From: Sian Eggington [REDACTED]
Sent: 09 April 2020 12:16
To: Sian Eggington
Subject: FW: Reference: R/58/20/HH
Attachments: 2376_02_01.pdf; 2376_02_02.pdf; 2376Cil.pdf; 2376Locmap2.pdf; 2376PPdocs3.pdf

You would have previously received an invalid letter from Arun Council, however please ignore this as some points are incorrect. I have been in correspondence with Lisa Coney the enforcement officer and she has advised that the application cannot progress until the following is received:

**Palm Cottage, 62 Ash
Lane, Rustington
BN16 3BT
Ref. 2376**

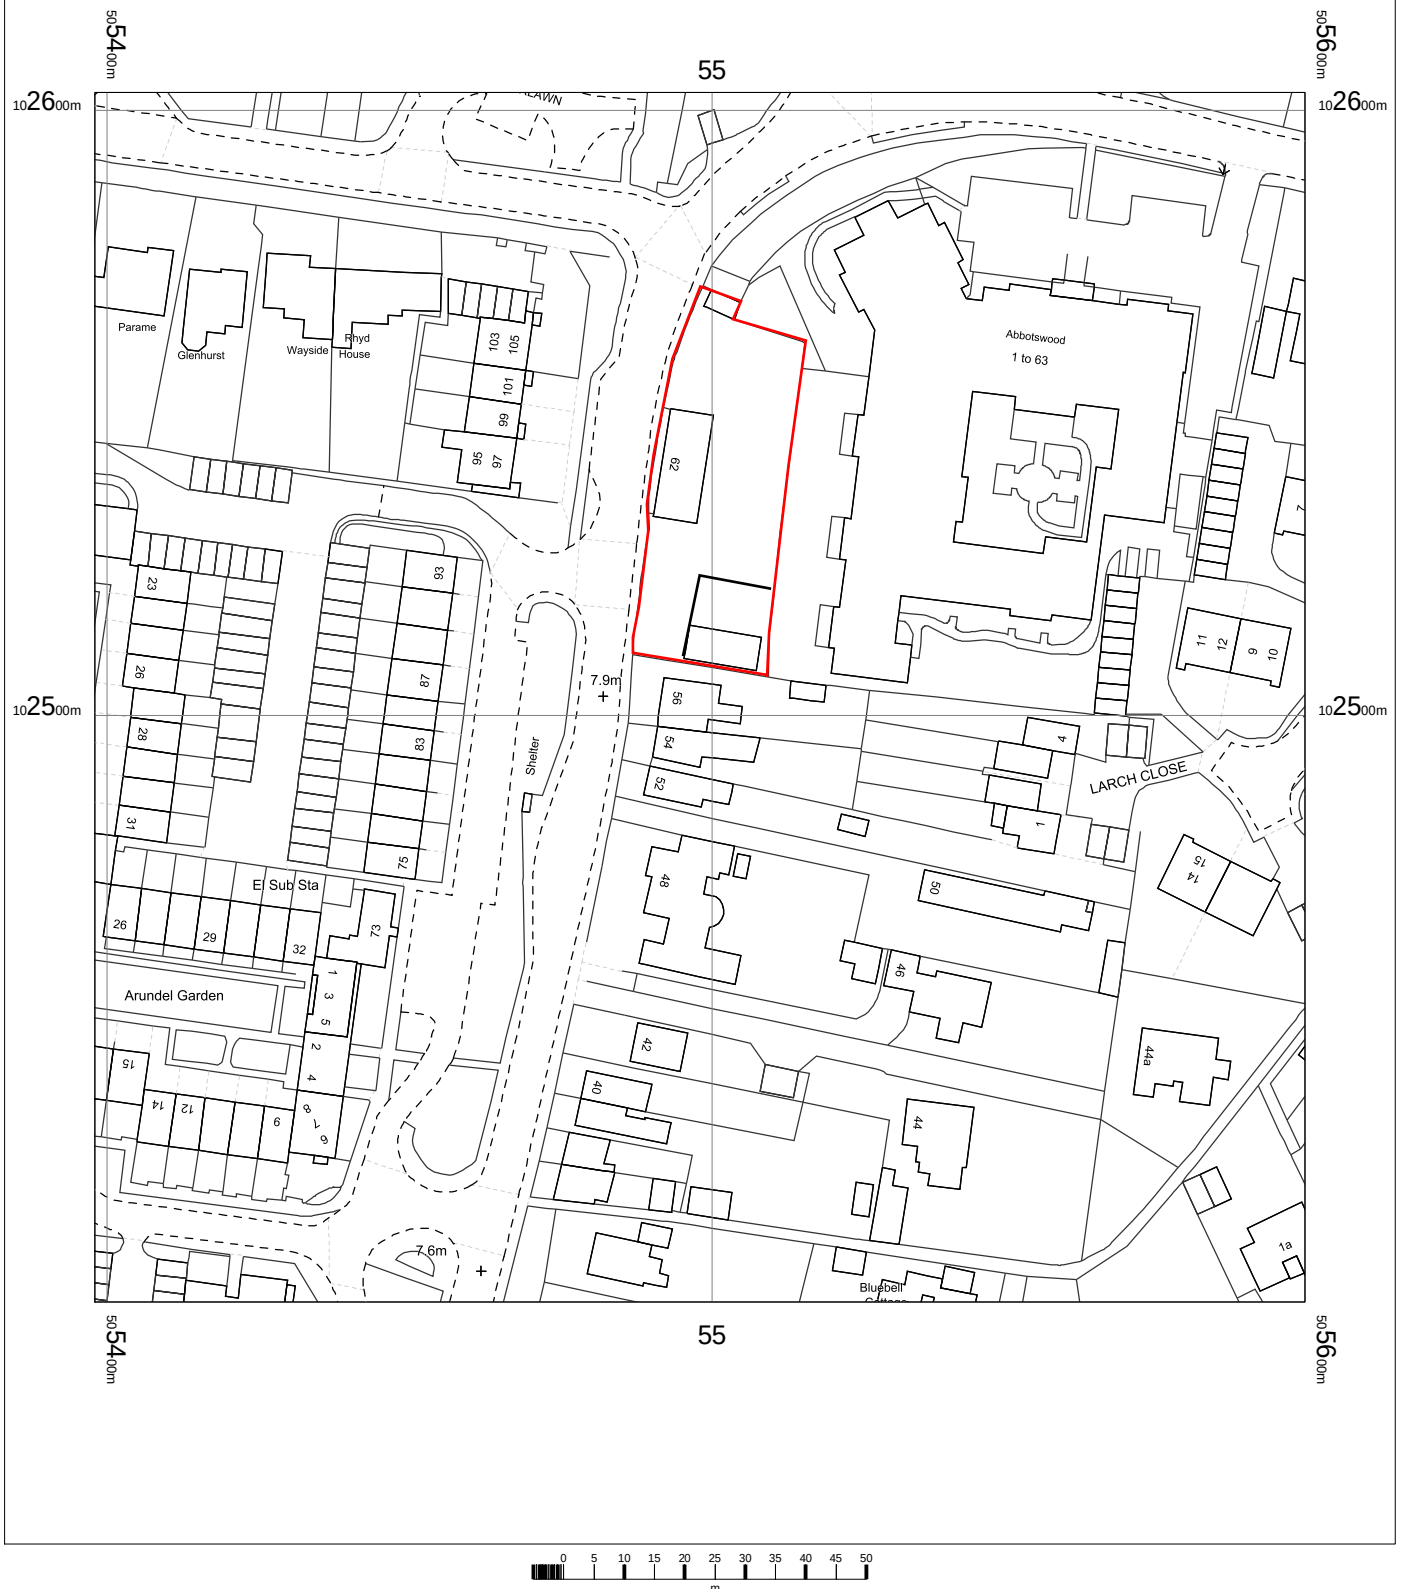
6. The red site outline must include the access to the site from the public highway. As the address given is Palm Cottage please outline the whole site in red. Please review and amend accordingly.
